The Member Secretary,  
Chennai Metropolitan  
Development Authority,  
No.8, Gandhi Irwin Road,  
CHENNAI -600 008

Letter No.B 2/32974/99

Dated: 27.07.2000.

Sub: CMDA - Area Plans Unit - Planning Permission -  
The proposal is for construction of Ground + 3  
floor residential building (56 dwelling units)-  
cum-commercial building (office) at T.S.No.543/11,  
Block No.31, Village Road, Mungambakkam,  
Chennai - Remittance of Development Charges and  
Other Charges - Requested - Regarding.

SITE PLAN & DETAILS  
 TAMILNADU HOUSING BOARD  
 PROPOSED FLATS AND OFFICE COMPLEX  
 IN T.S. No.543/11, BLOCK NO.31,  
 VILLAGE ROAD - NUNGAMBAKKAM  
 CHENNAI.

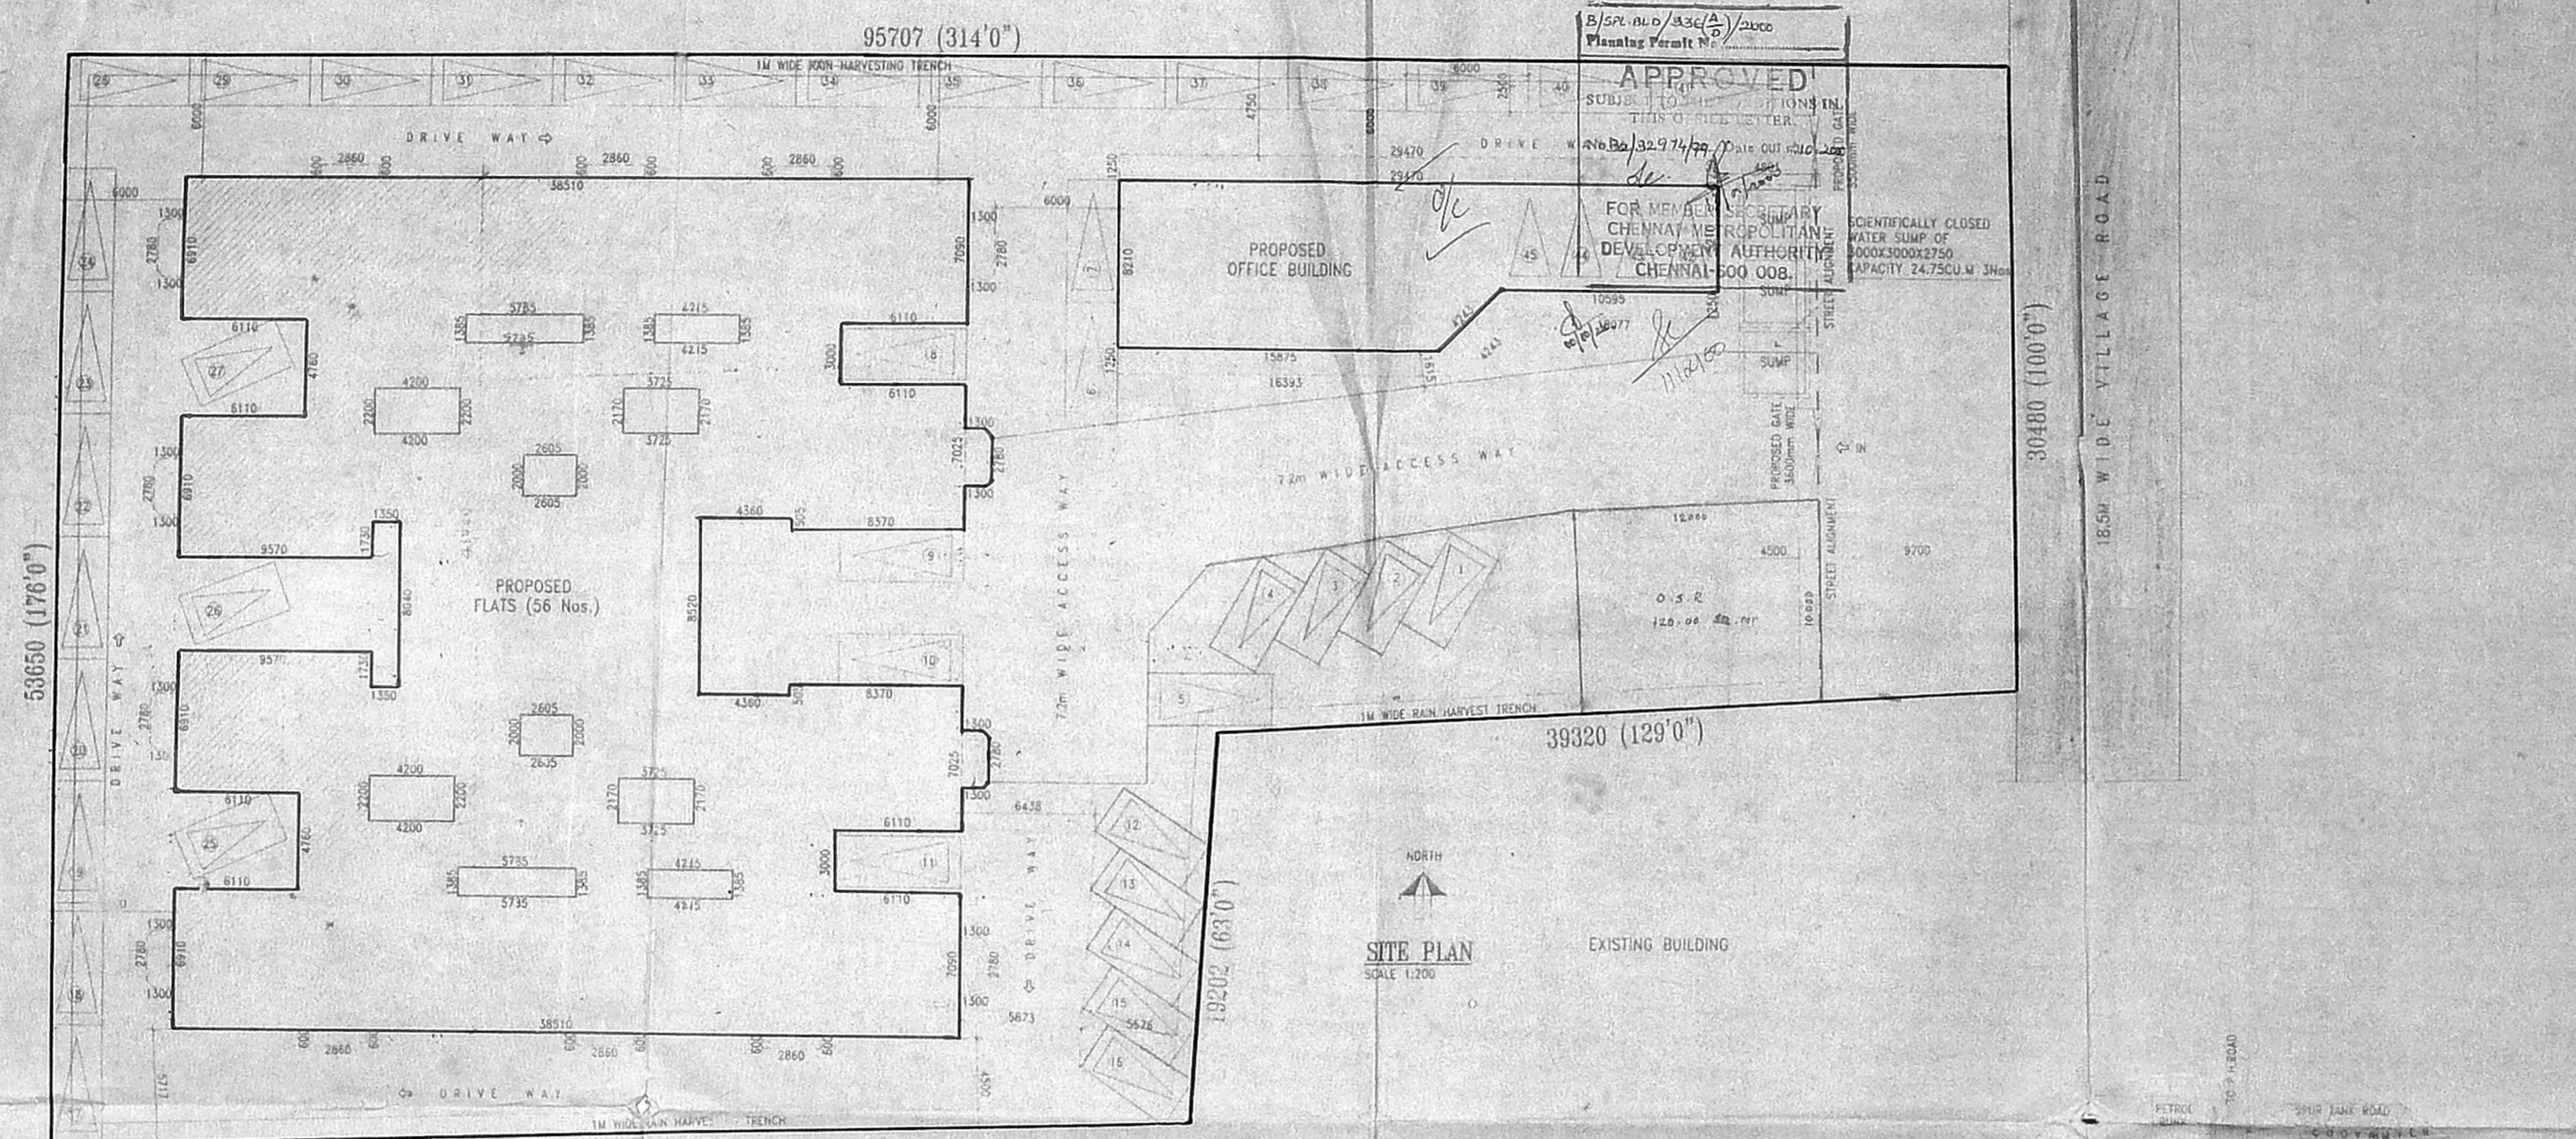
6. You are requested to furnish the 5 copies of revised plans shifting the location of Open Space Reservation Space adjacent to S.A. line to the size of 12.0M x 10.0M (120M<sup>2</sup>).
